**From:** planning  
**Subject:** FW: app3/2017/0436 52a Knowsley Road

**From:** Bloomer, David [<mailto:David.Bloomer@lancashire.gov.uk>]  
**Sent:** 03 July 2017 14:53  
**To:** Victoria Walmsley  
**Cc:** LHS Customer Service; planning  
**Subject:** app3/2017/0436 52a Knowsley Road

PROPOSED GROUND FLOOR

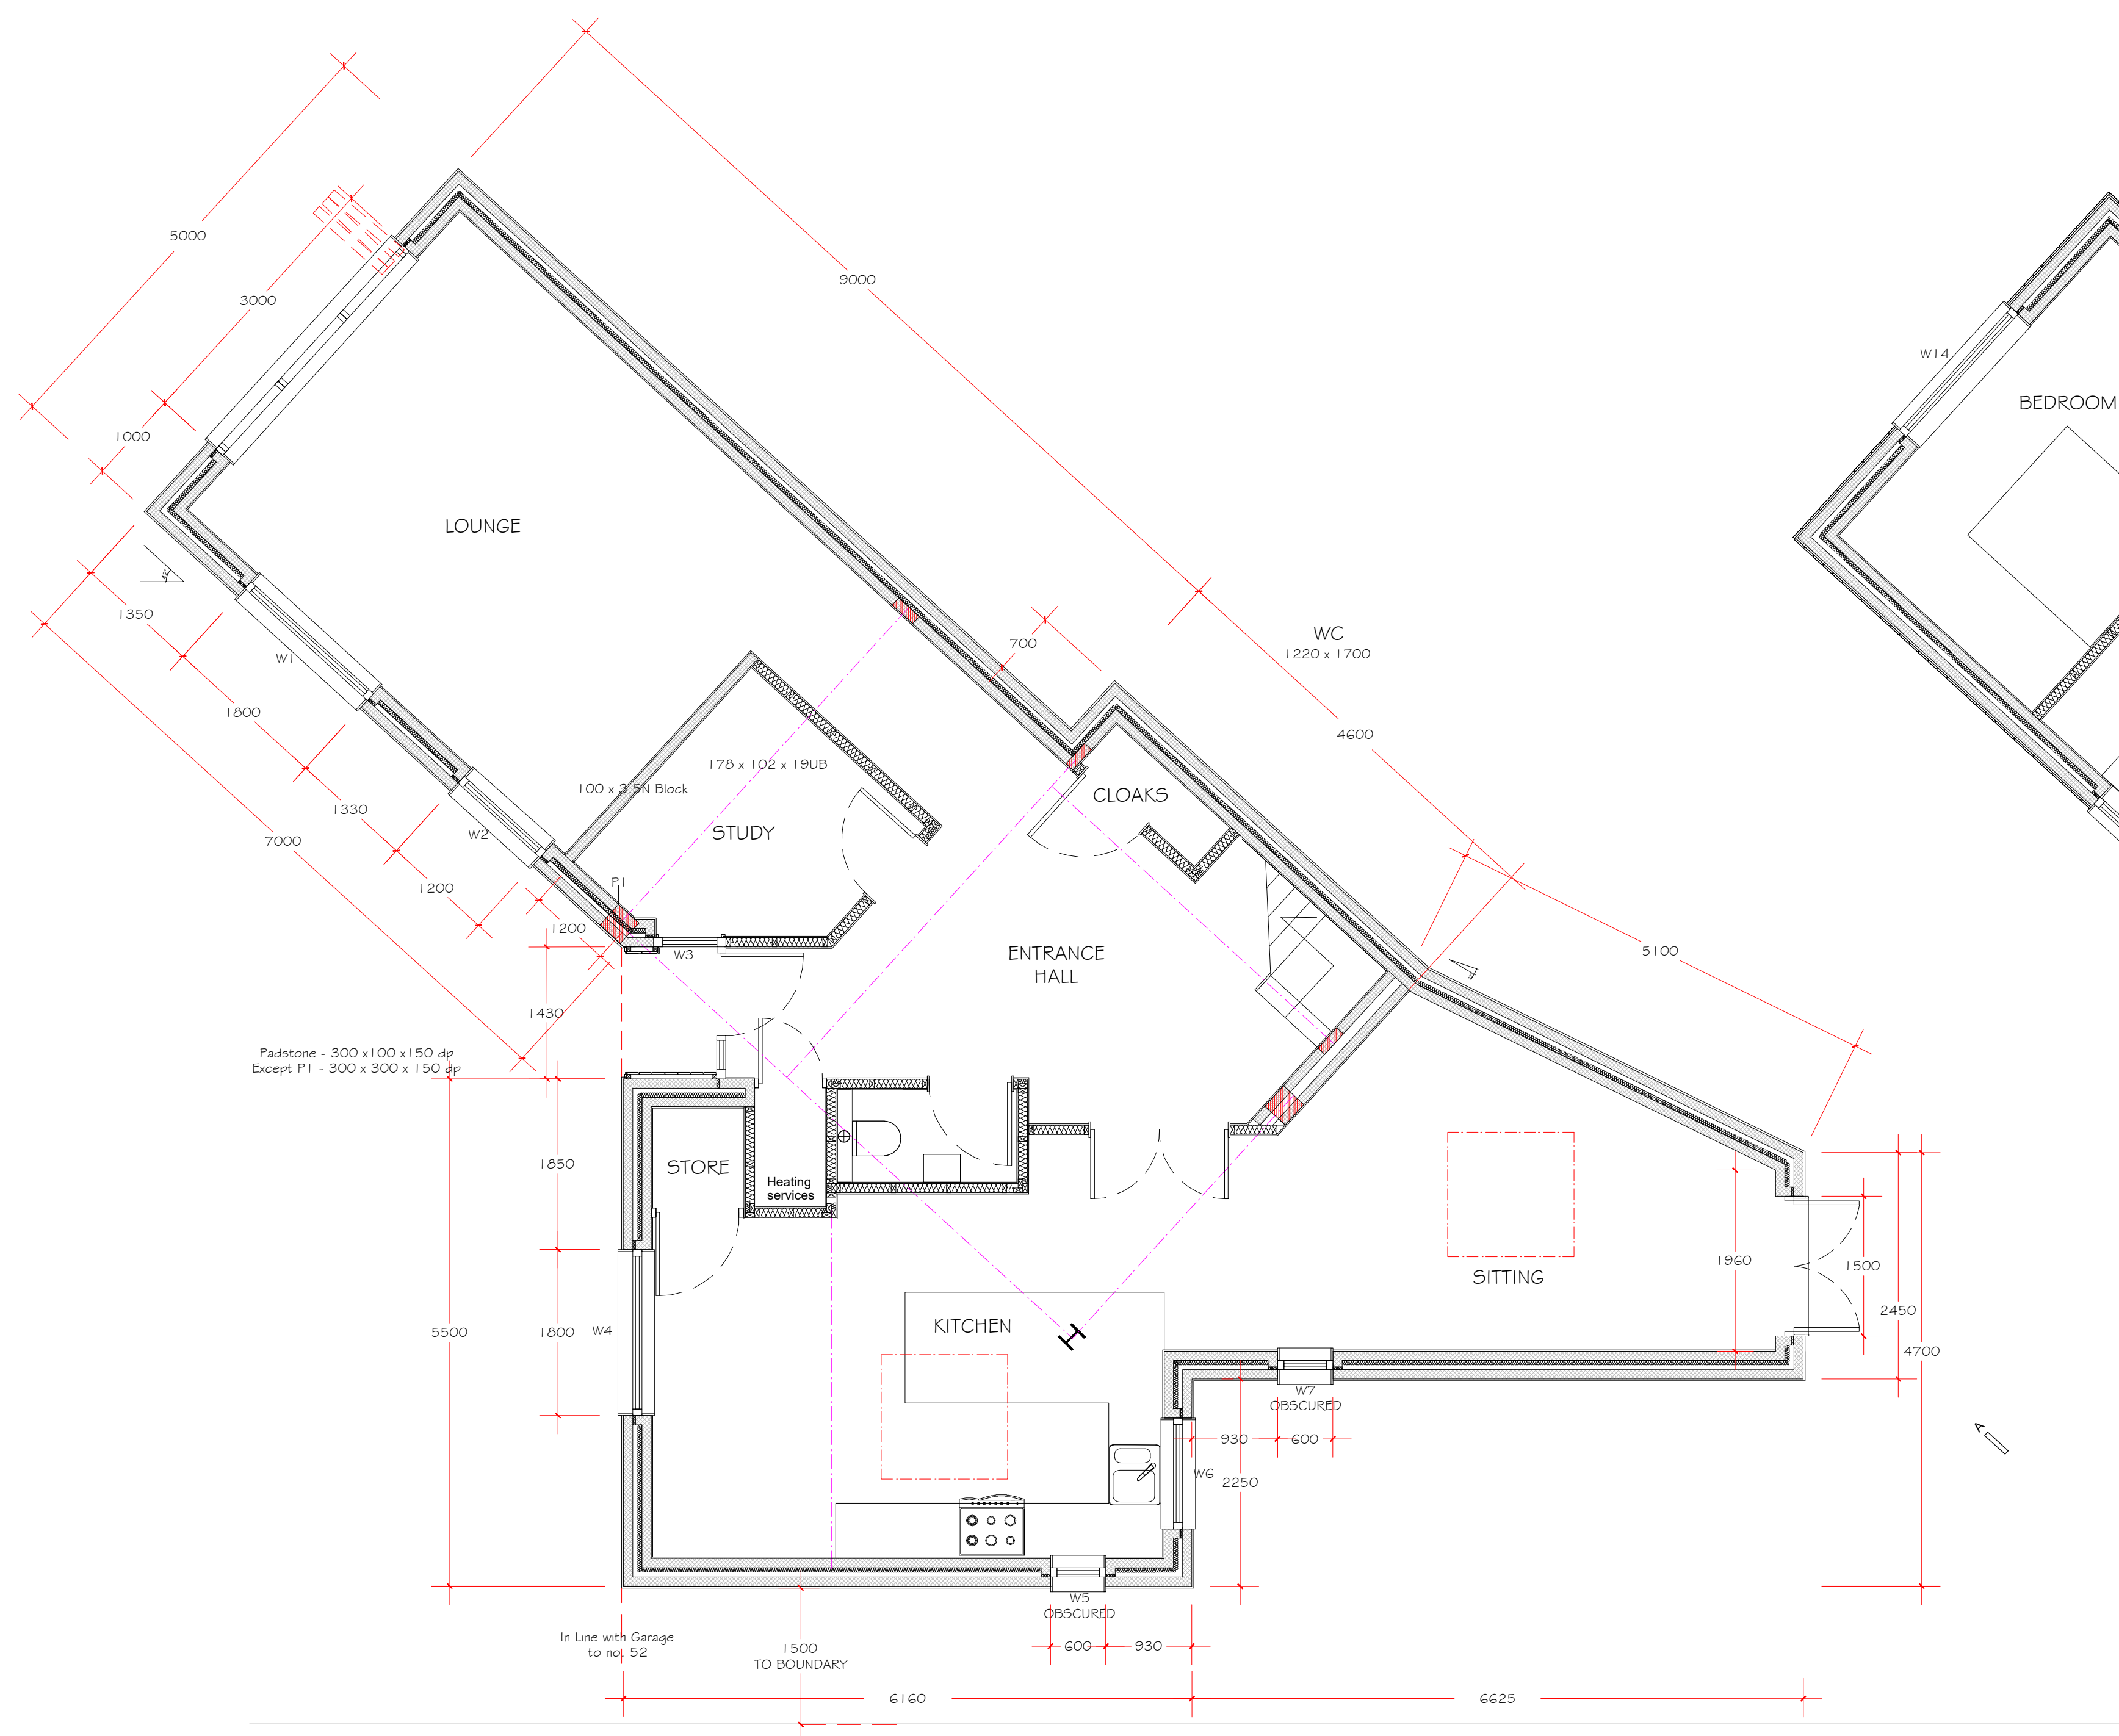
Increase in the number of bedrooms from 2 to 3  
Loss of one of the parking spaces – provision down to 2 from 3  
The loss of the turning head.

Rev	Date	Revision	project	client	scale	Notes		
			PROPOSED NEW DWELLING KNOWSLEY ROAD WILPSHIRE	JONATHAN RUMBOLL	1:100 @ A1			
					drawn: DW	checked: FH		
					date: 20/12/16			
			drawing title: SITE PLAN		project no: PHD/PS	drg. no: 500	rev: c

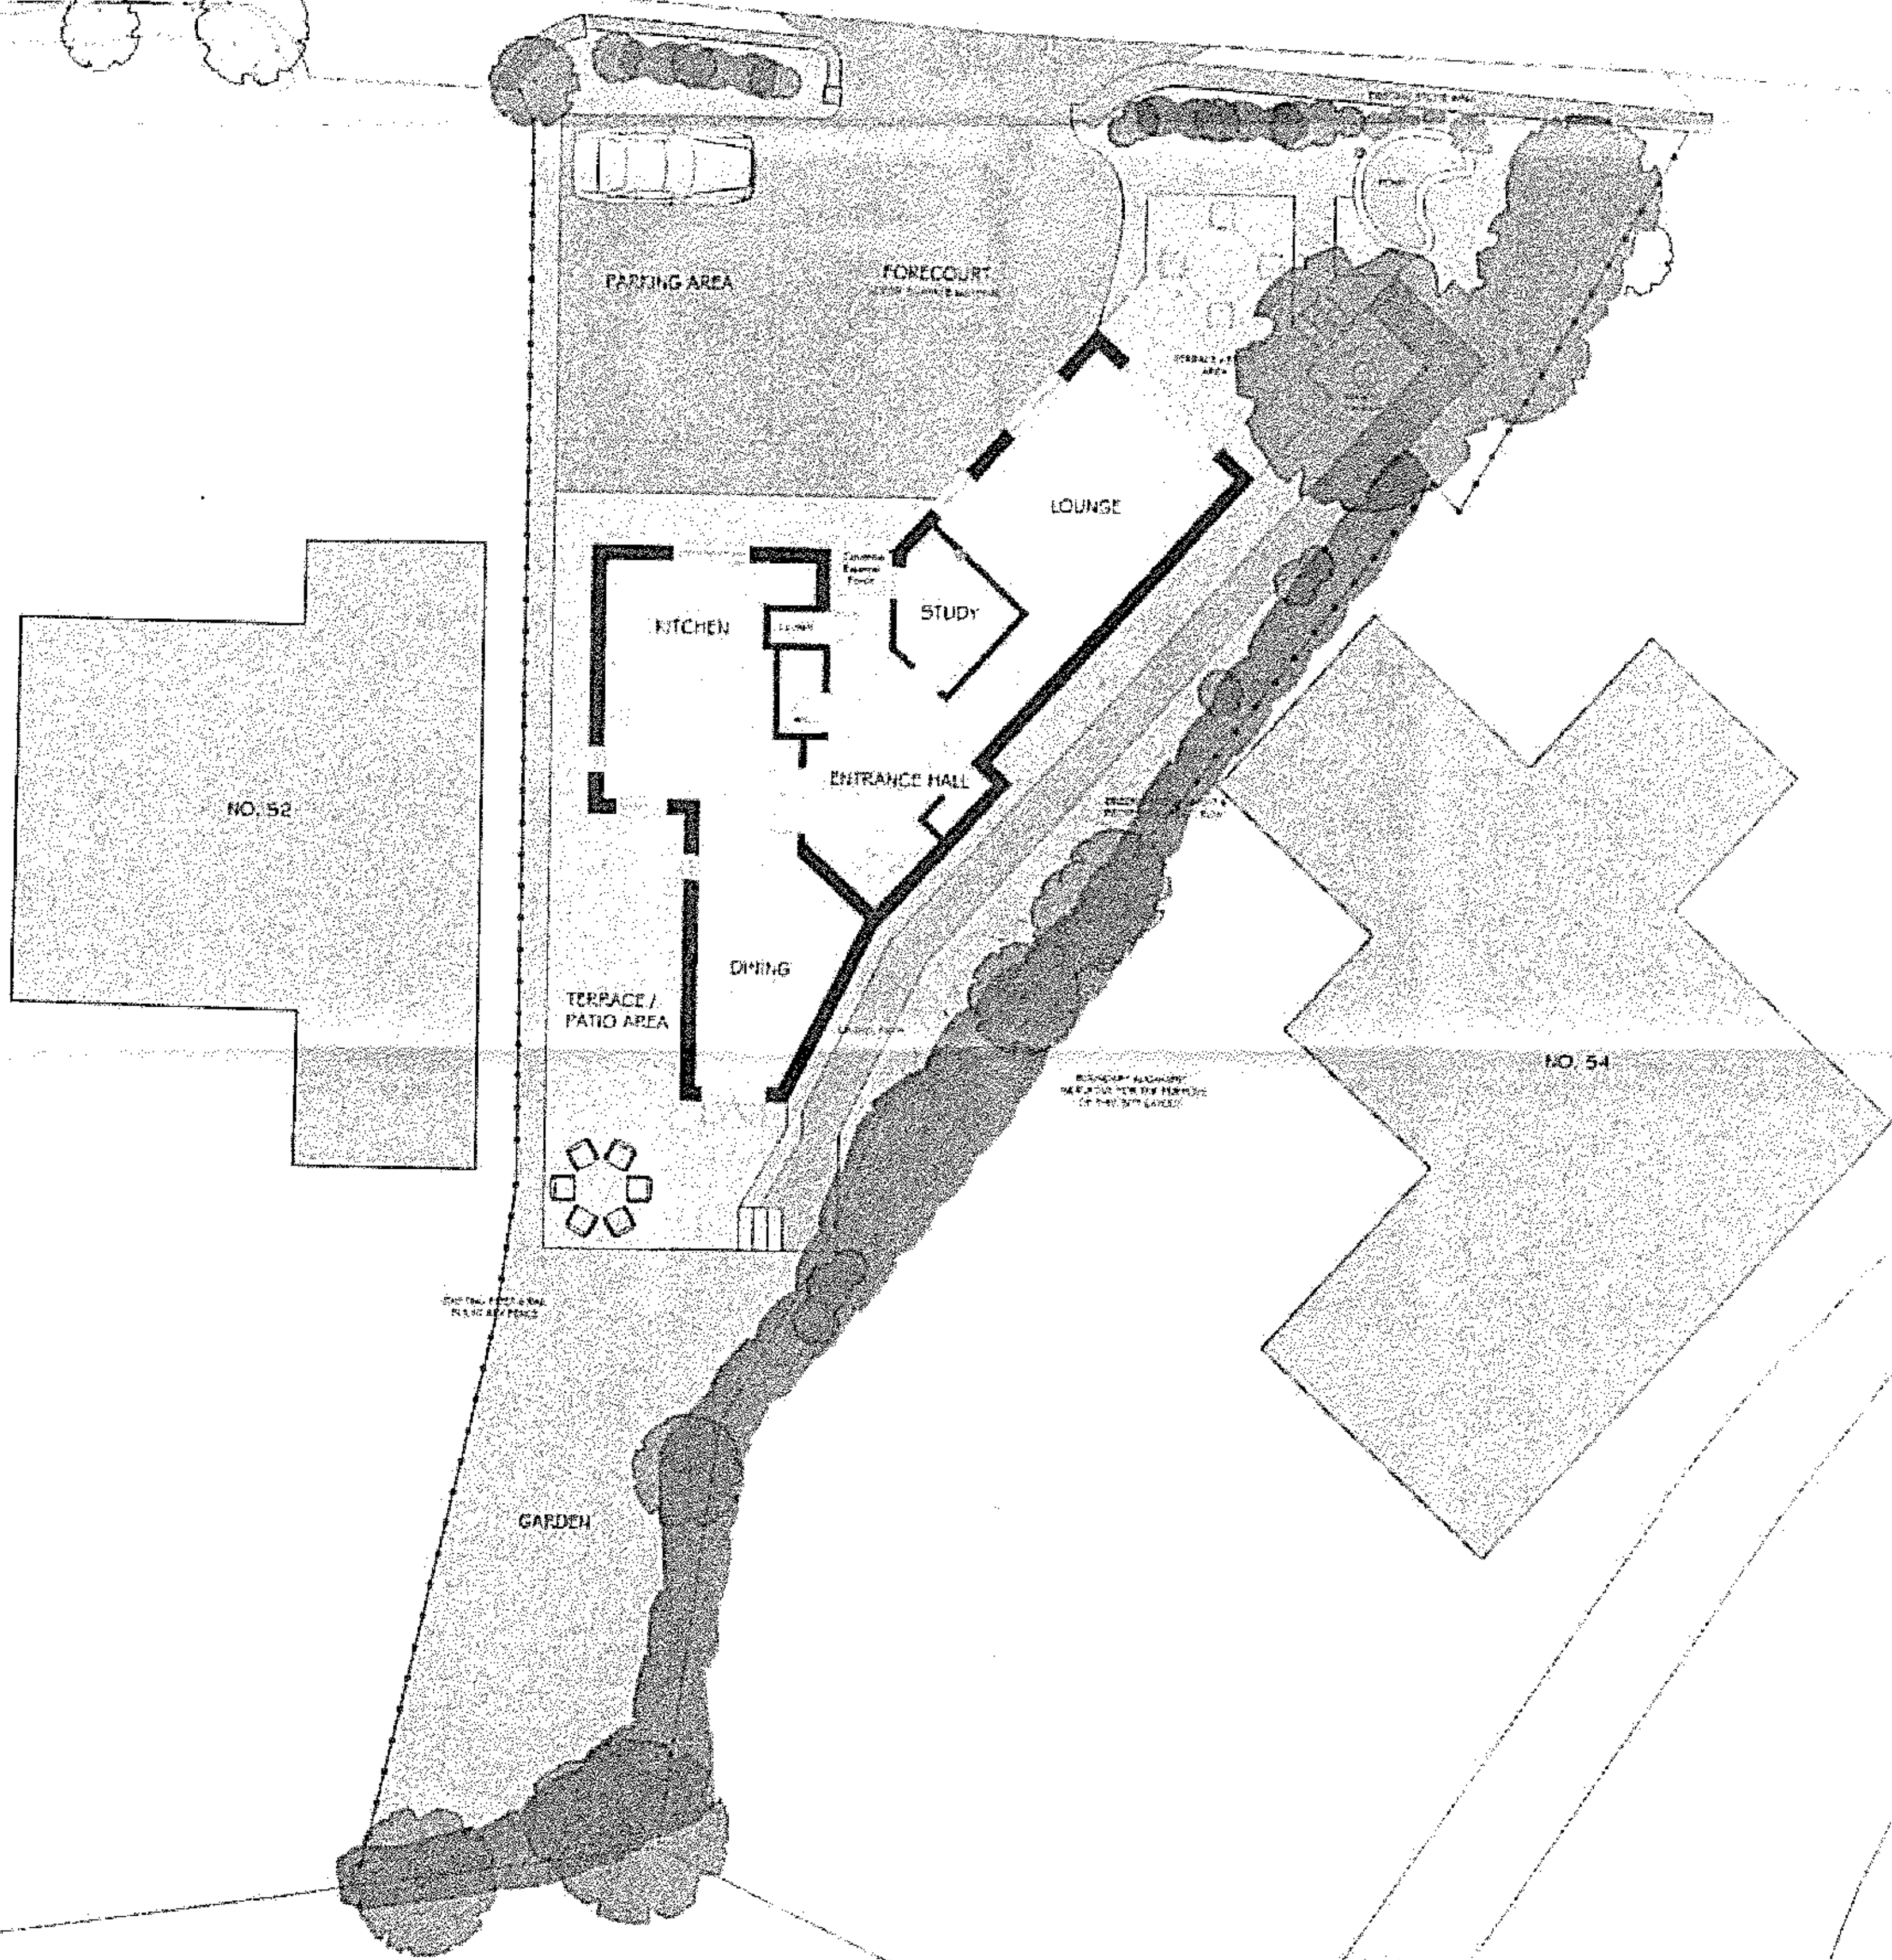
Whilst I would be minded to raise no objection I would need clarification on the above points and should the turning area be omitted I would need to be satisfied that vehicles would still be able to enter / leave in forward gear.
